Our Case Number: ACP-324410-26

Re: Proposed West Clare Railway Greenway Section 1: Kilrush to Kilkee Project
Kilrush to Kilkee via Moyasta, Co. Clare

WEST CLARE RAILWAY GREENWAY – SECTION 1 KILRUSH TO KILKEE VIA MOYASTA

Submission to An Coimisiún Pleanála
Case HA03.324410
30 September 2026

Figure 4-31 Typical Cross Section

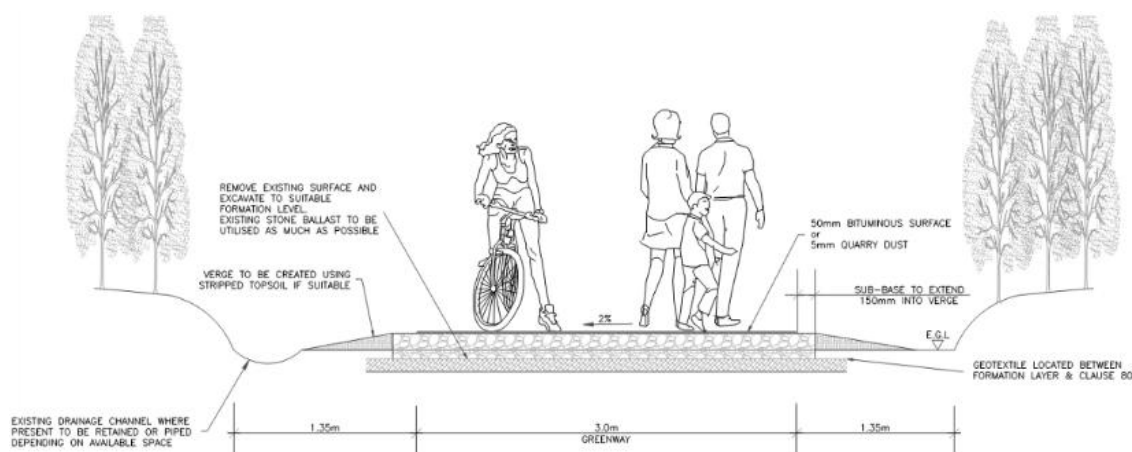
The official lodged material identifies a minimum Greenway dimension of approximately 2.6 m on the bridge embankment and approximately 3.7 m on the bridge. Those dimensions must be tied to exact chainages and measured clear widths. They do not, by themselves, prove a safe operating envelope for tractors, trailers, implements, loads, mirrors, overhang, Greenway users, fencing and any refuge. [S3, S7]

The lodged cross-sections identify approximately 2.6 m on the bridge embankment and approximately 3.7 m on the bridge. [S7] Those dimensions do not, by themselves, demonstrate a safe operating envelope for a tractor, trailer or implement, its mirrors and overhang, a vulnerable Greenway user, barriers or parapets, and a usable refuge. The applicant should provide measured clear widths, chainages and swept-path evidence for the actual agricultural combinations that must use the route.

The safety question is simple: when a tractor, trailer, tracked machine or livestock group is committed to the confined shared section, where does a child, wheelchair user, person with a buggy, cyclist or dog walker go? Signage cannot create width. Road markings cannot create a refuge. Courtesy cannot create stopping distance.
